2020/90996 Objection. The Developers Design Statement and Drawings contain inaccurate and misleading statements.

**A-A** | section A-A  
1 : 100

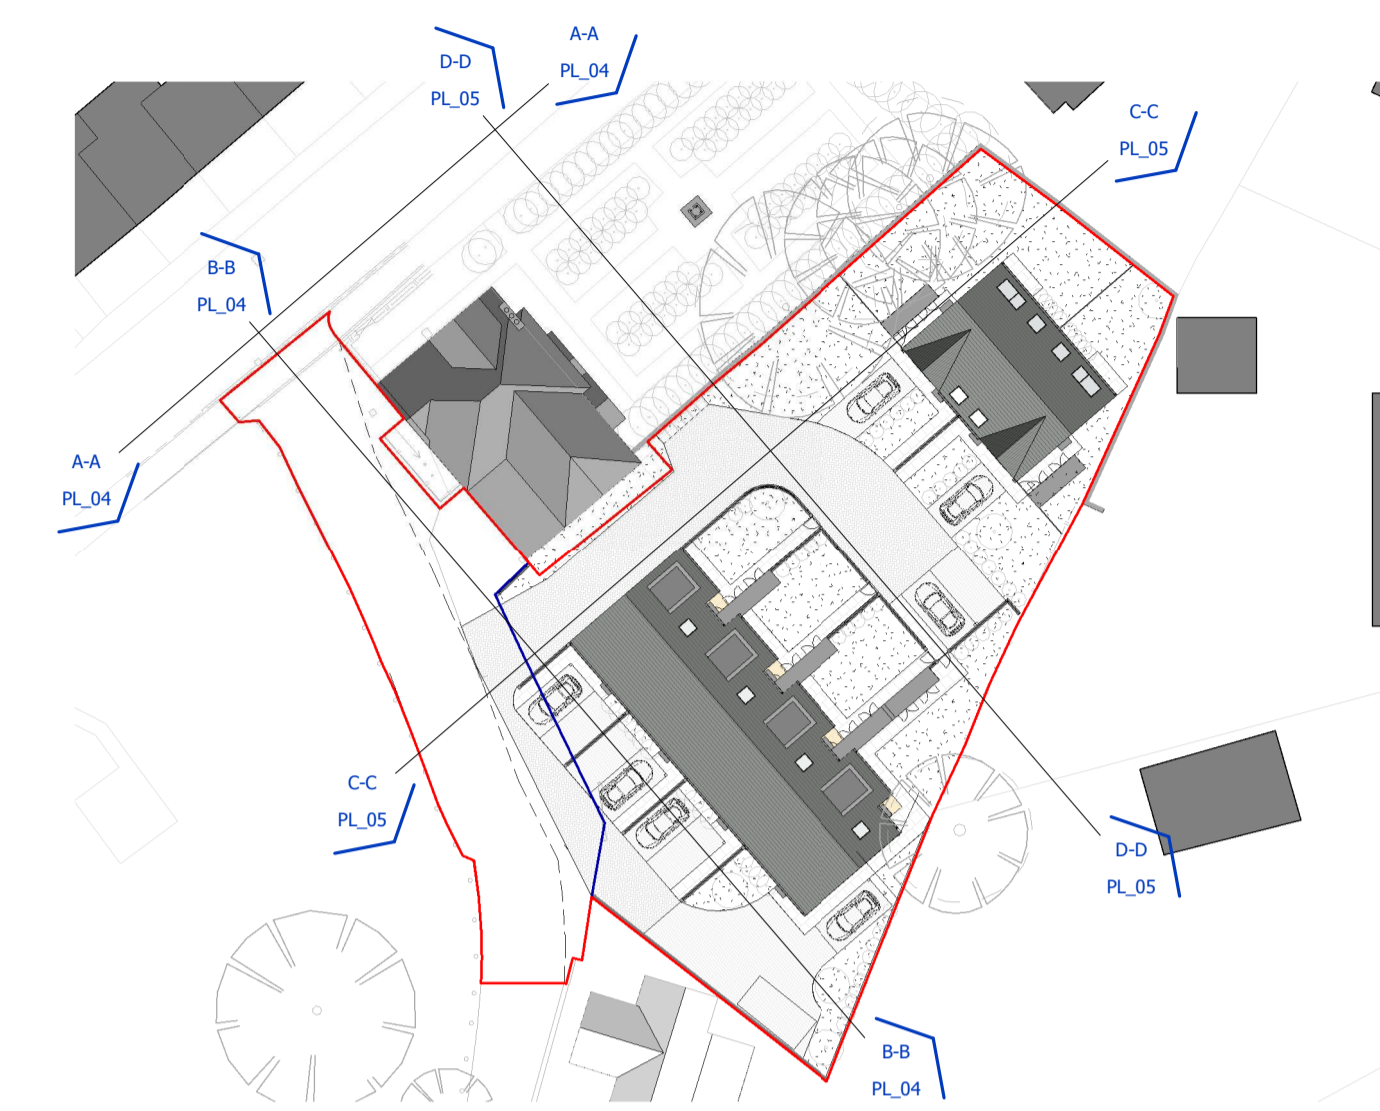
The above wall is in the order of **3ft 1in high (95cm)** at the top of the drive. The developers plans state the wall as being **5ft high**. This wall tapers to 1.2m clearance from [redacted]

Similarily, [redacted] front wall, which is **1ft 10in high (55cm)**, roadside. The developers plans show it to be **6ft high**. The road is considerable higher than land on [redacted] side of the wall. Traffic shown on plan 801873 will have clear view into [redacted], as well as encroaching on land [redacted] I am worried that anyone undertaking a desktop review will be given the impression that [redacted] is partially screened and not adversely affected by the proposed development. **Can request that planners challenge the developer on these errors.**
